**Haweswater Aqueduct Resilience Programme, Bowland Section**

**Ecology Comments on Planning Application 3/2021/0660  
(Ribble Valley Borough Council)**

**John Jones  
Senior Ecologist  
Design & Construction Service  
Lancashire County Council**

**28<sup>th</sup> September 2021**

LCC\_RVBC-BO-FIG-009-02-03  
Figure 9B.3 Water Vole Baseline

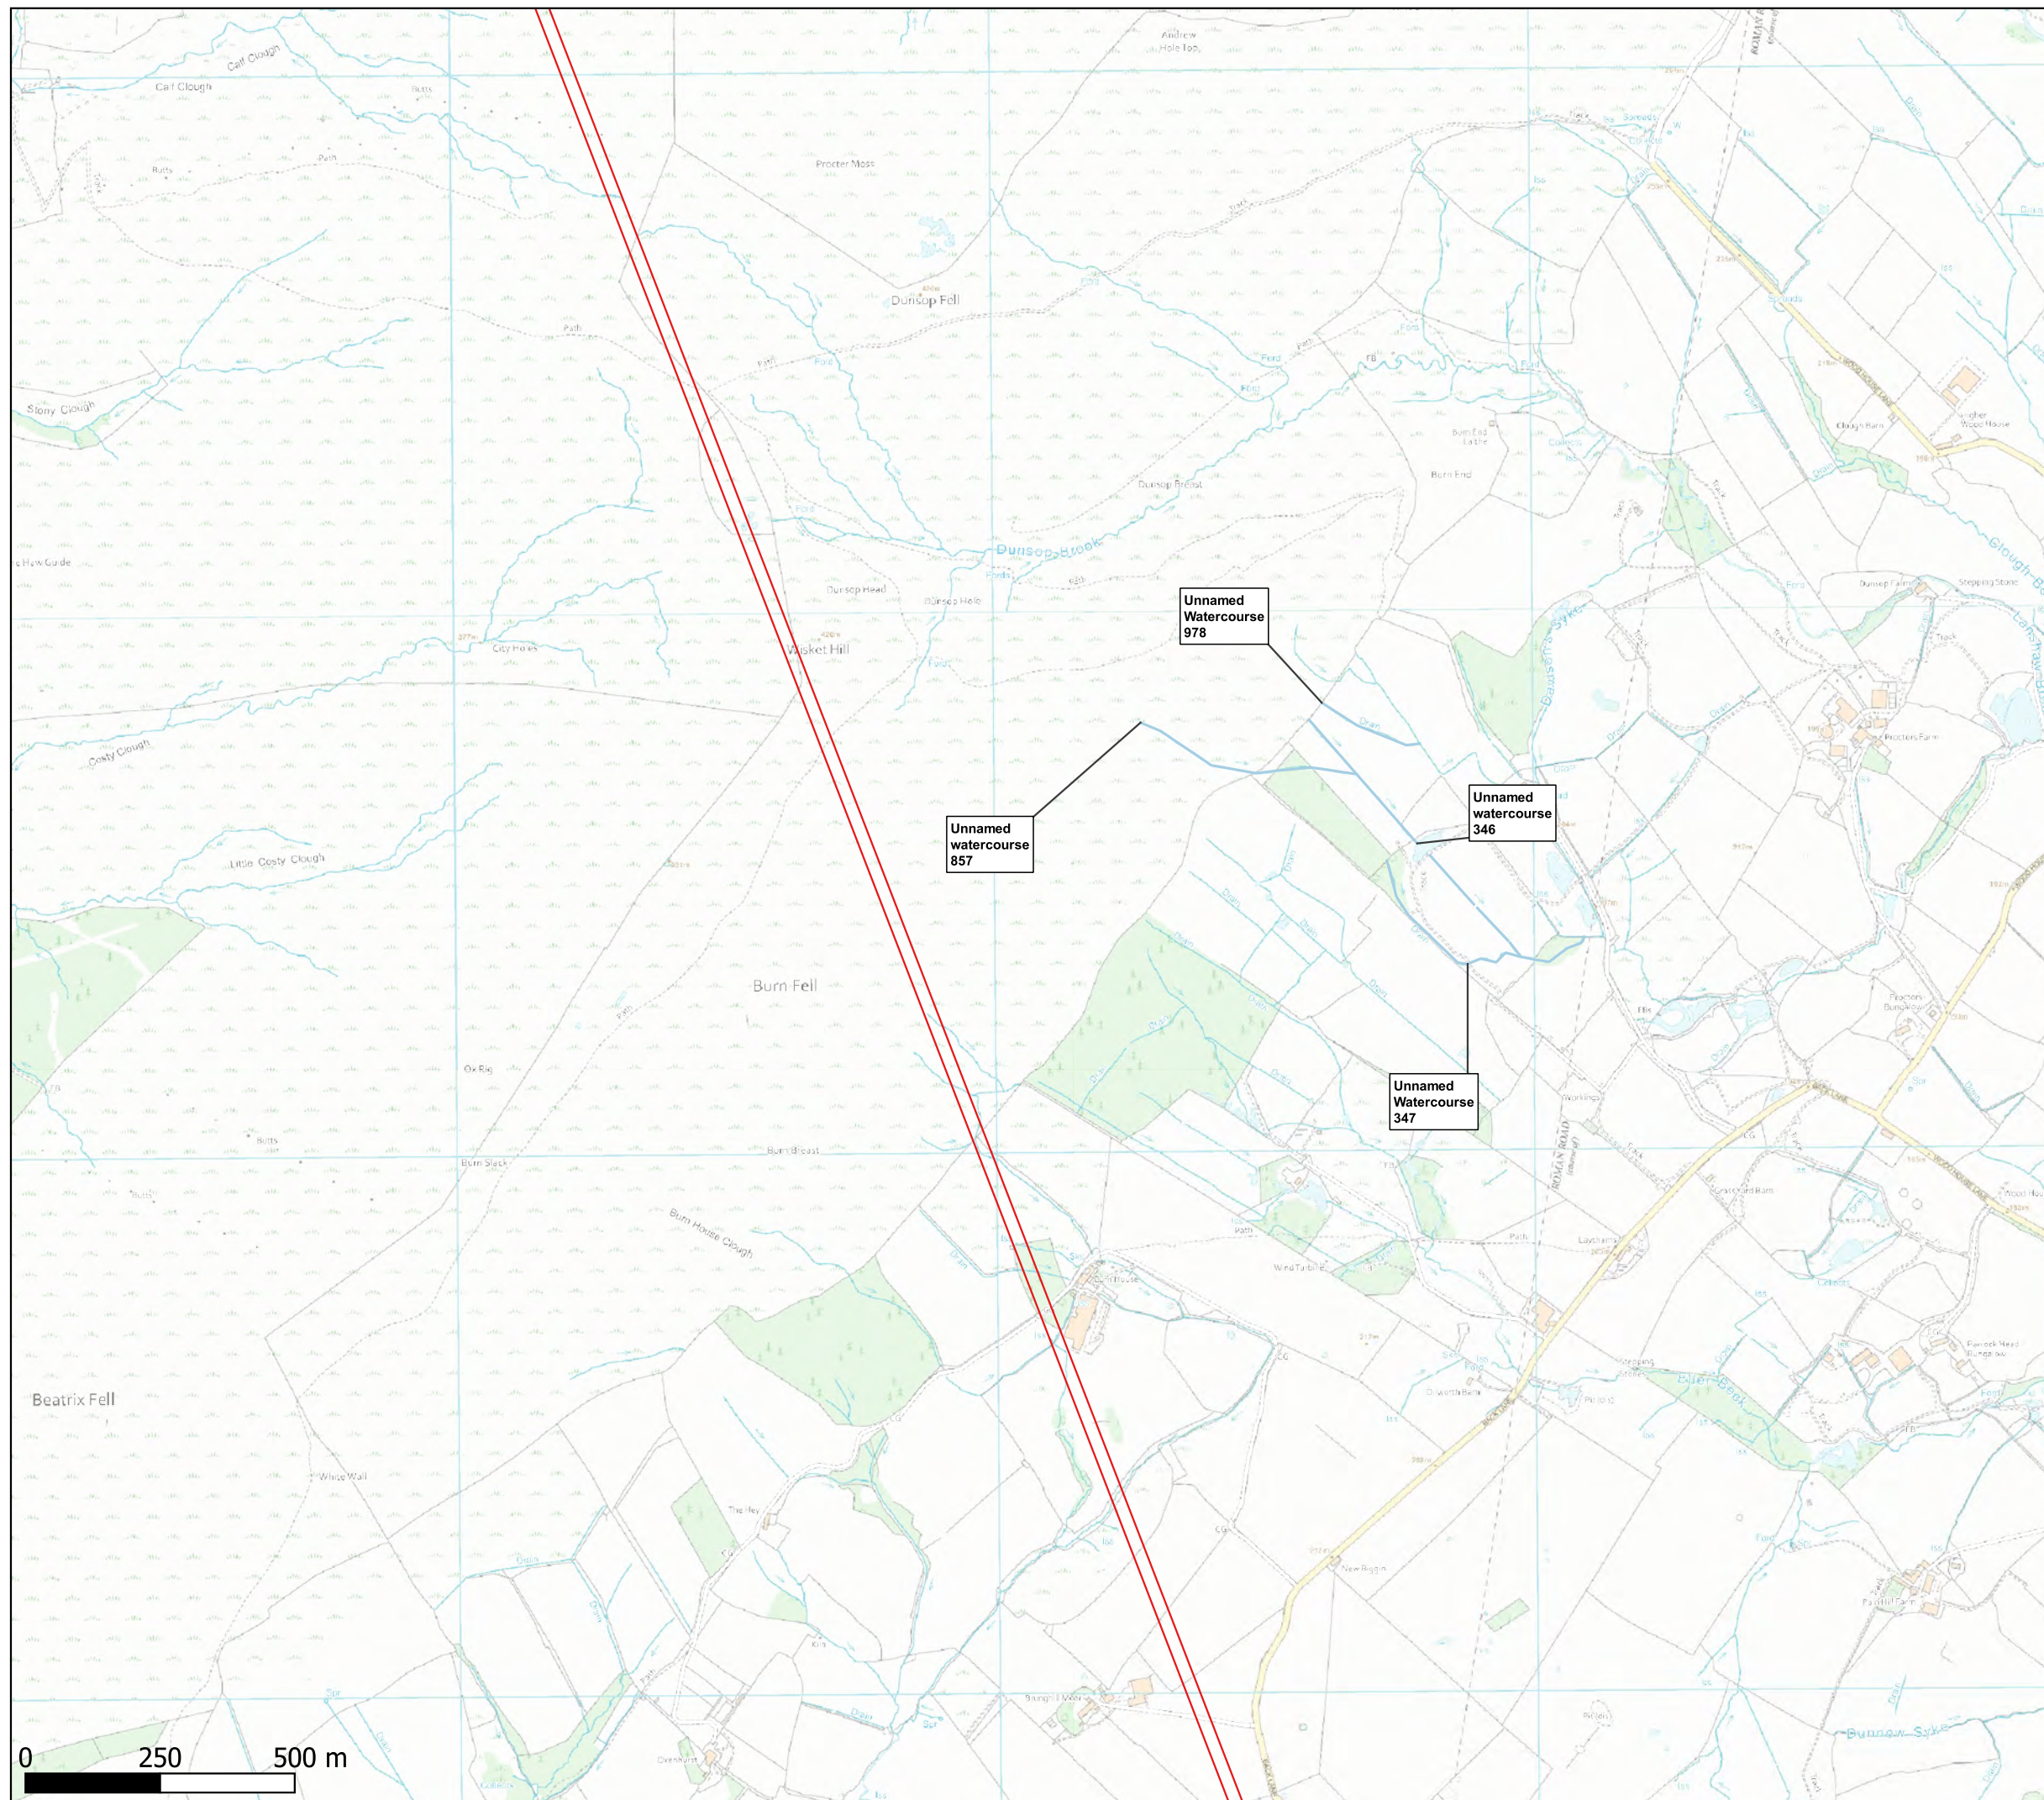
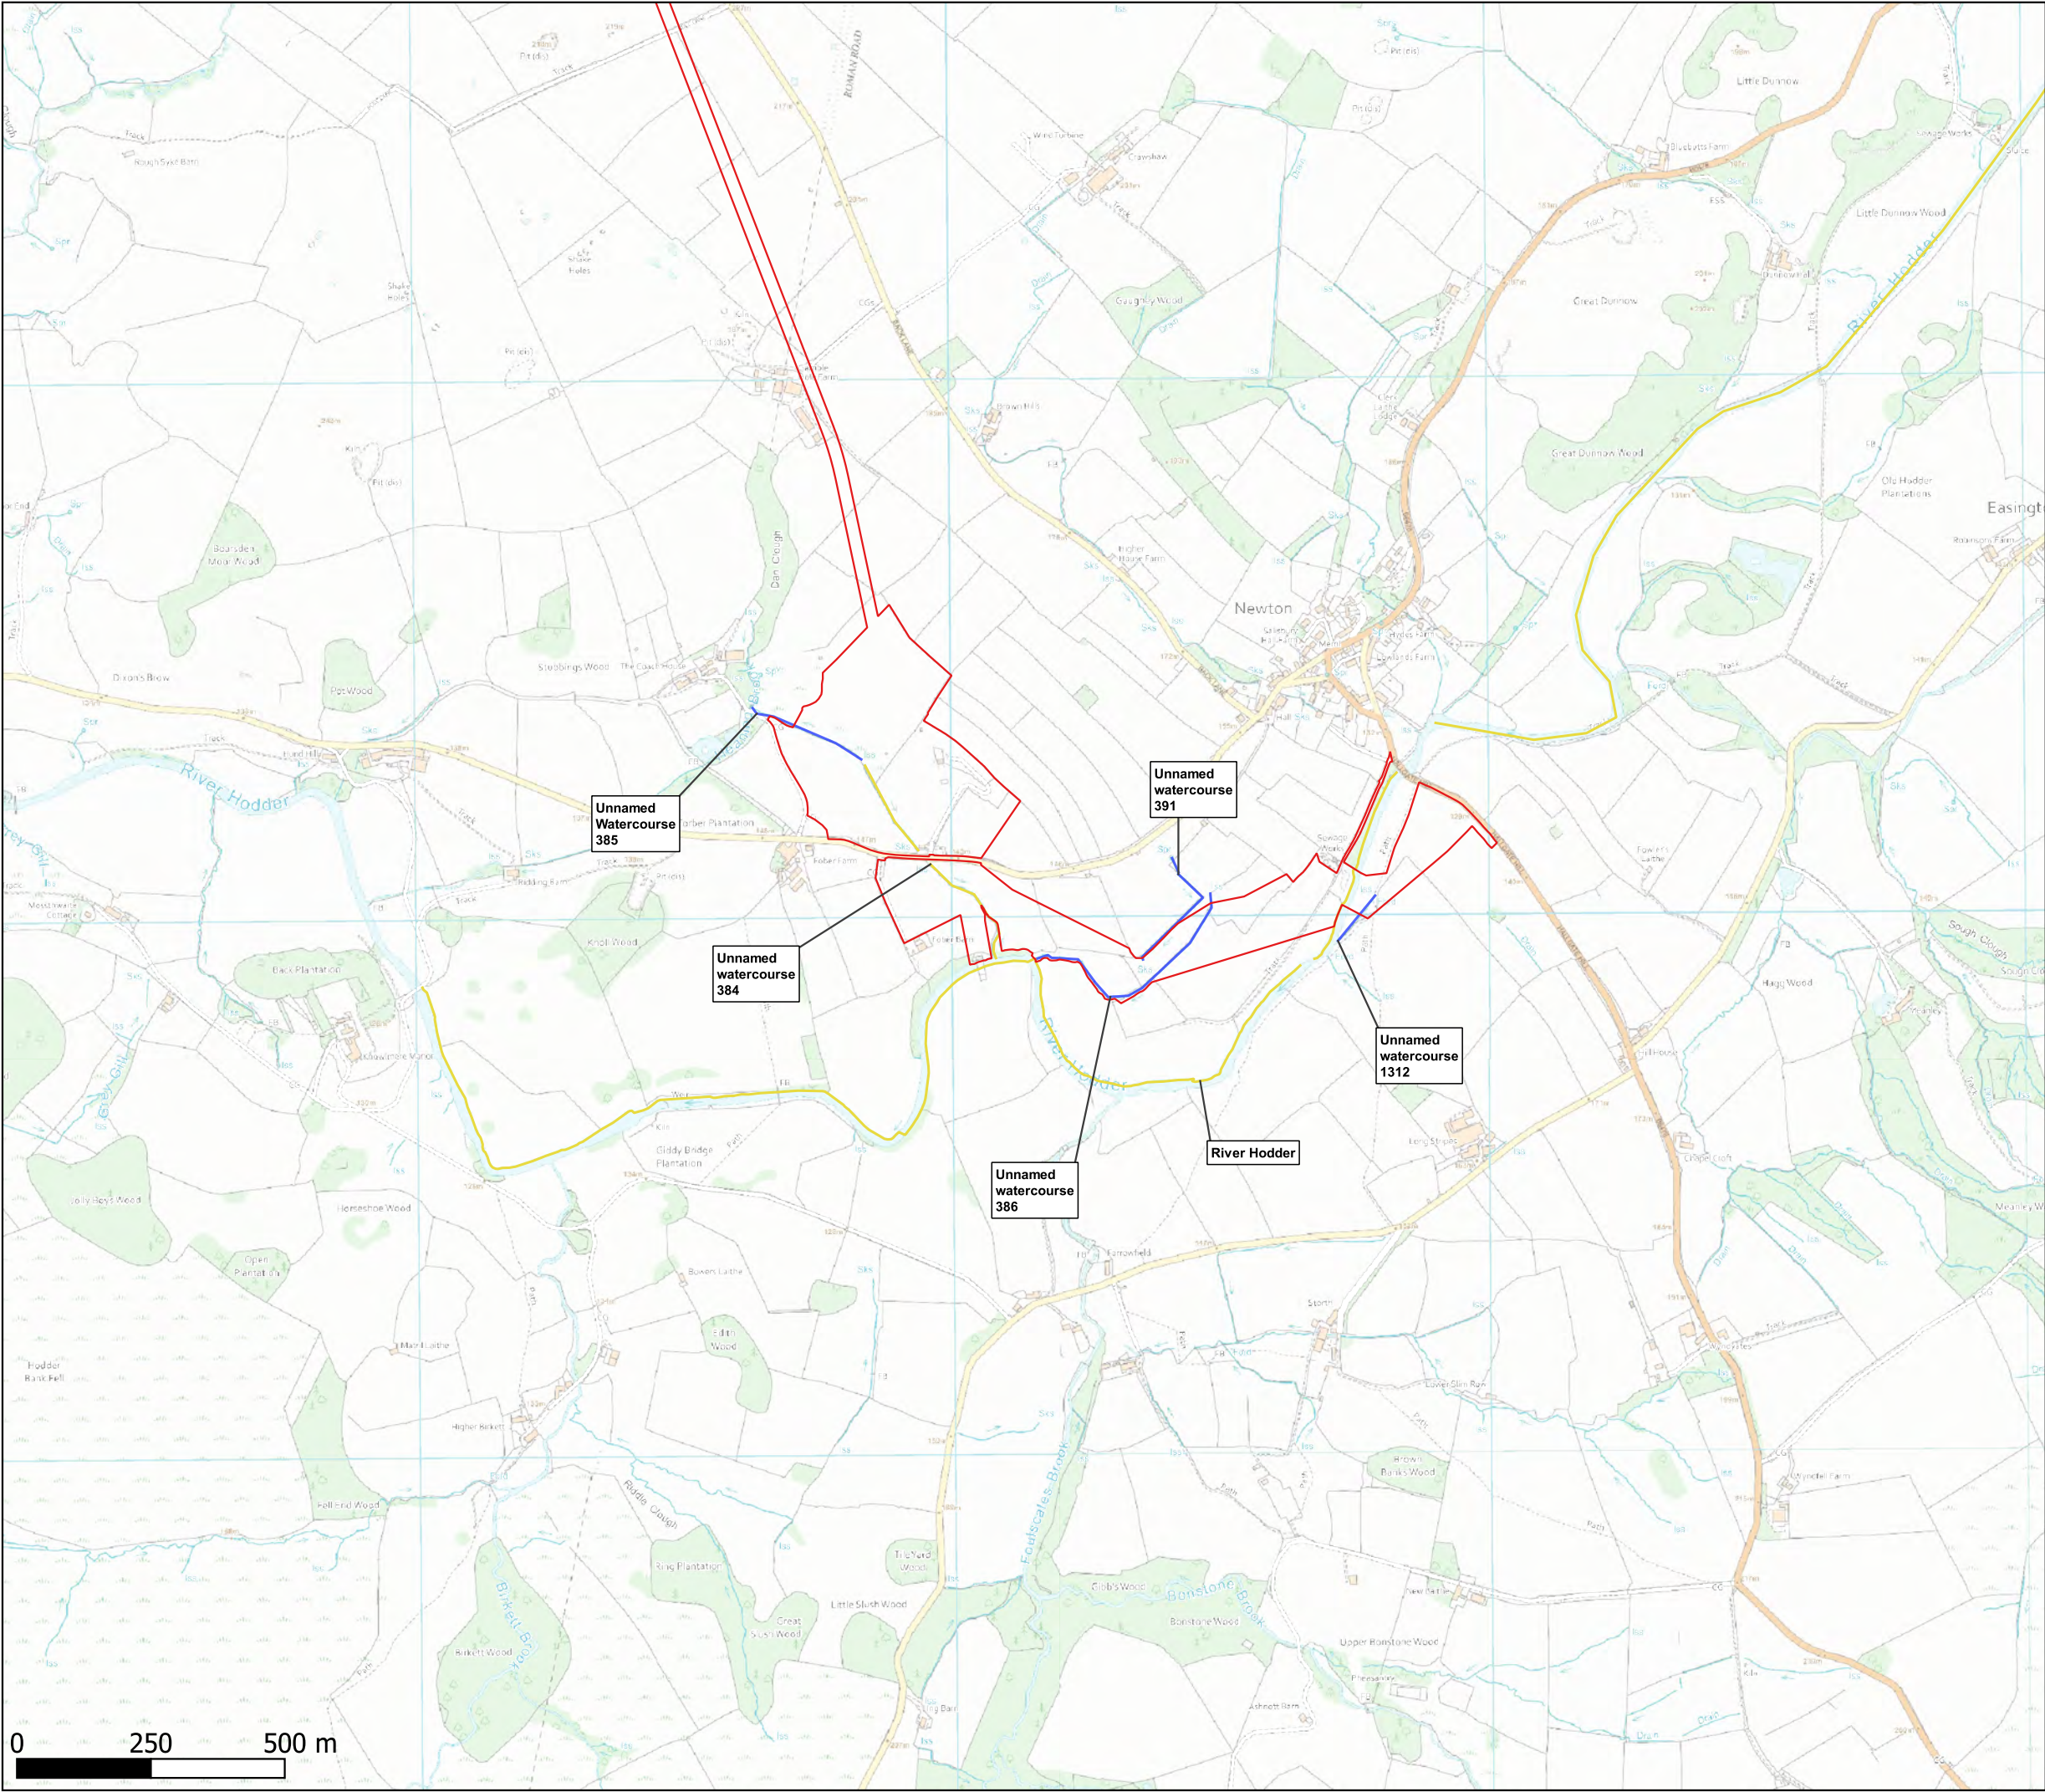
The Environmental Statement and water vole survey appendices appear to refer only to water vole surveys undertaken by Bowland ecology in 2019-20. These surveys did not identify the presence of water voles. However, the 2019 surveys were undertaken during suboptimal water course conditions following an exceptionally wet autumn and the surveys comprised one visit only, which does not meet recognised guidelines (see stated limitations within the Bowland Ecology report).

However, additional water vole survey results by RSK, undertaken in 2020 and 2021, have been included with the otter survey appendices. These results include evidence of water voles (including burrows and feeding signs) in locations that would be affected by the proposed development, including the Newton-in-Bowland compound and vicinity. These results and likely associated impacts do not appear to have been addressed within the relevant ES chapters. A licence from Natural England is likely to be required before works affecting water voles and their burrows could commence.

It is acknowledged within the RSK water vole report that not all surveys were undertaken during the appropriate survey season.

- All necessary water vole surveys need to be completed in accordance with recognised guidelines.
- The Environmental Statement needs to be updated to take into account the RSK water vole survey results and any further surveys.

Figure 3: Newton-in-Bowland indicative site layout 1

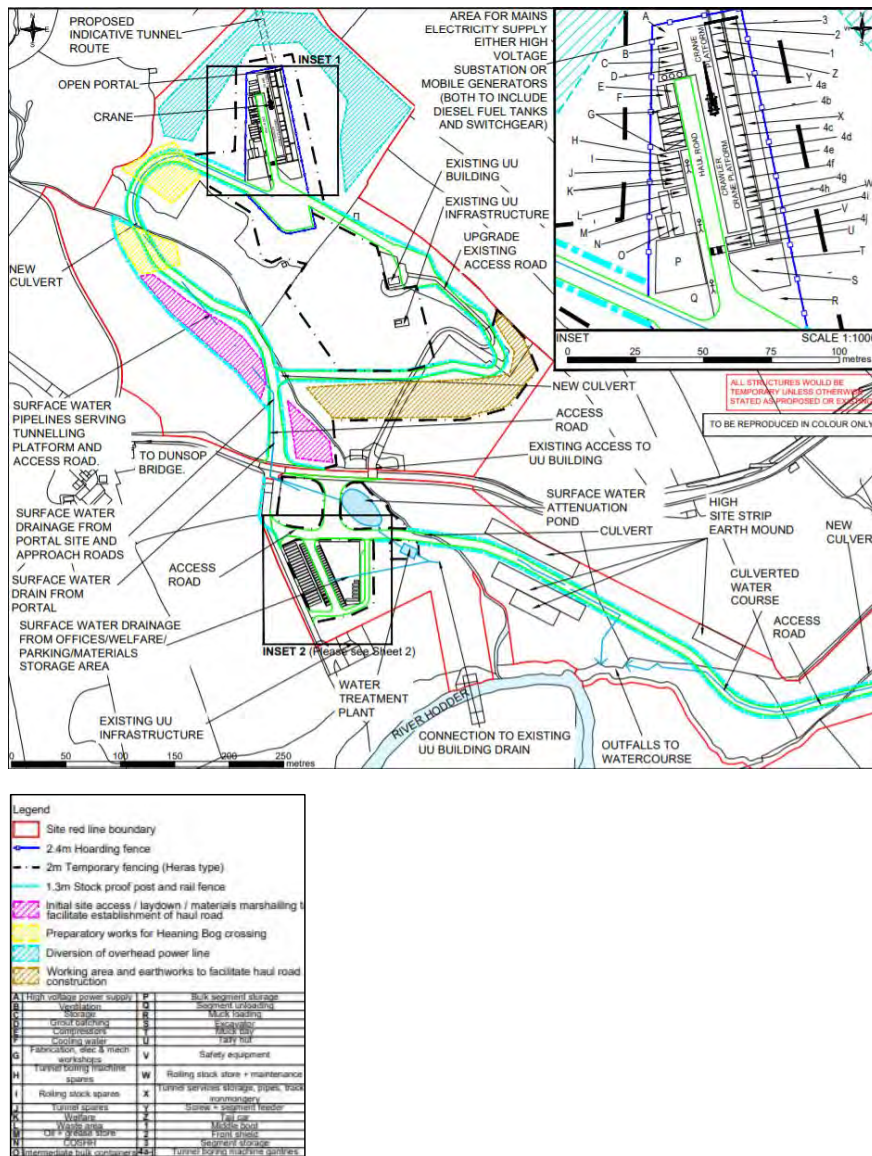
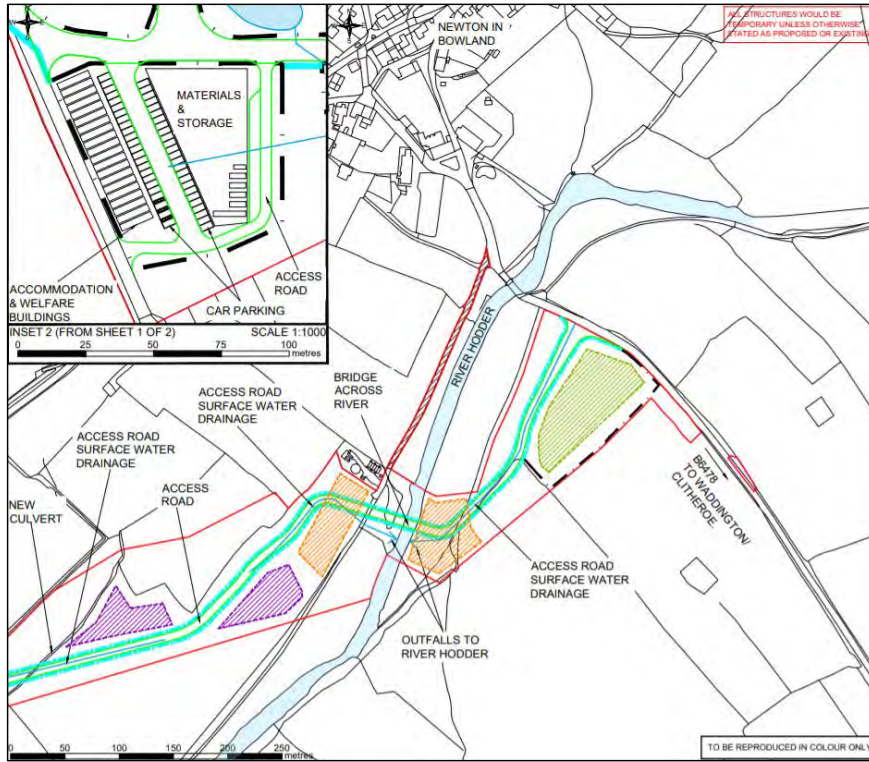
- The Newton Compound would affect Gamble Hole Farm Pasture (BHS 65SE09). This site comprises habitats of principal importance (NERC Act, 2006) as well as irreplaceable habitats. Potential impacts on this BHS and associated fen habitat include habitat loss and degradation, habitat fragmentation, hydrological impacts, compaction, disturbance, pollution and sedimentation (with implications for species populations). Significant adverse residual effects on this site are predicted. It is not clear from the information submitted with the application that it is not possible to amend the scheme to avoid or further reduce impacts on

Gamble Hole Farm Pasture. Ribble Valley Borough Council should not approve the application unless they are satisfied that there are no alternatives to the proposed design that would avoid or reduce impacts (see mitigation hierarchy below). It is indicated within the application that assessments are ongoing to determine the feasibility of further reducing impacts on this BHS, including bridging the access road over sensitive habitats, avoiding the need for excavation and reducing direct impacts. This assessment should be completed and firm proposals, which can be shown to be feasible, should be submitted before the application is determined as part of the consideration of the mitigation hierarchy and in order to inform the extent and nature of impacts and associated mitigation/compensation measures. It is stated within the application that compensation for the residual effects/significant impacts on Gamble Hole Farm Pasture is to be agreed. Firm proposals should be submitted prior to determination of the application in order to demonstrate feasibility of adequate compensation measures.
